## Engineers Comments Regarding Surface Water Drainage

| <b>Application Reference:</b>   | A/44/26/PL                                                                                                                                                                                                  | <b>Reviewer Reference:</b> | ADC/EXT5/AF |
| <b>Site Name:</b>               | Former Shrublands Nursery Roundstone Nursery Angmering BN13 4AT                                                                                                                                             |                            |             |
| <b>Assessment Number:</b>       | 3                                                                                                                                                                                                           |                            |             |

Client	SIGMA HOMES		
Scale	1:200 @A1	Date	JUL 2025
Drawn	AK	Checked	BO
Job No	21-254	Drawing No	21-254-702
Rev	E	Designed	AK
		Approved	BAC

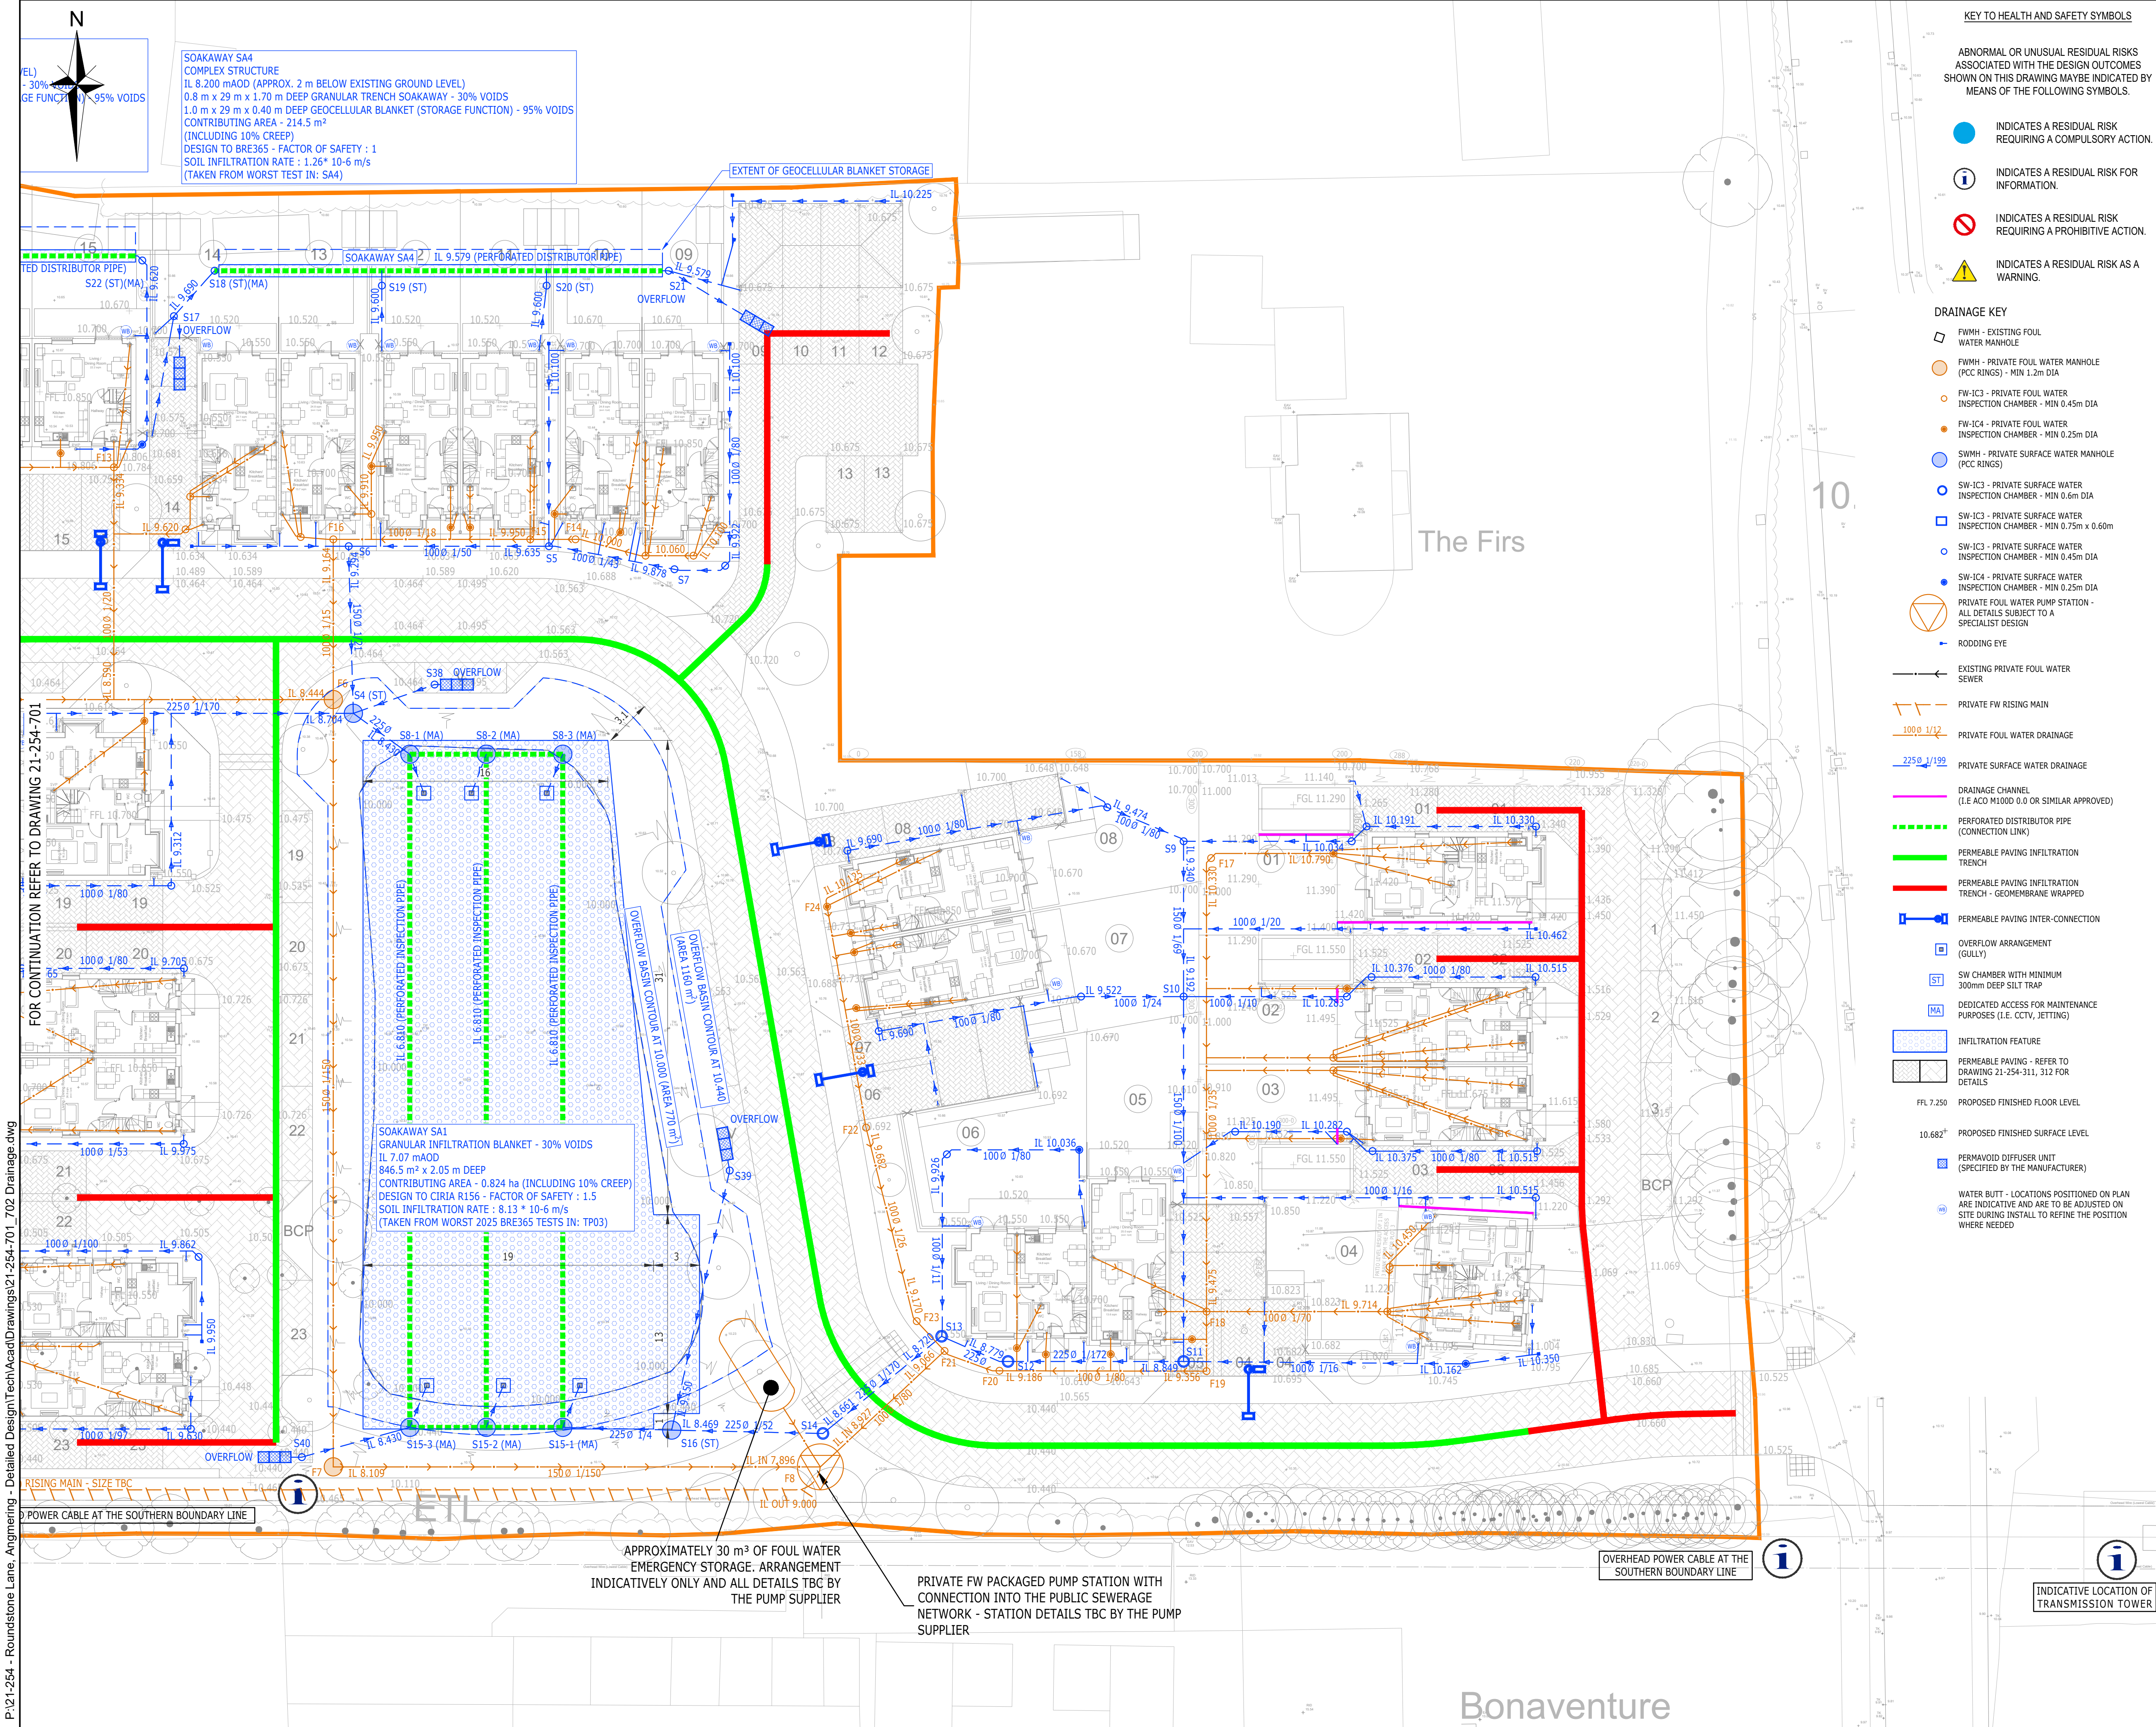
- 1.1. Water butts are noted in the Drainage Statement report to be retrofit at the existing properties but are not currently shown on all properties on the revised drainage layout plan 702E. Plots 1, 2 and 3 appear to have been omitted. The product specification should also be provided as a technical design.
- 1.2. The groundwater monitoring within the Southern Testing report indicates peak winter grounder around 19<sup>th</sup>-24<sup>th</sup> February 2026 with the highest reading at 6.07m above Ordnance Datum (AOD) at

- 1.7. Further information is required for the water butts as a technical design.
- 1.8. The letter report dated 16 July 2026 notes 'new positions are shown' on an updated version of Drainage Layout 702, however, this drawing is not submitted for review. The complete design package should be provided.
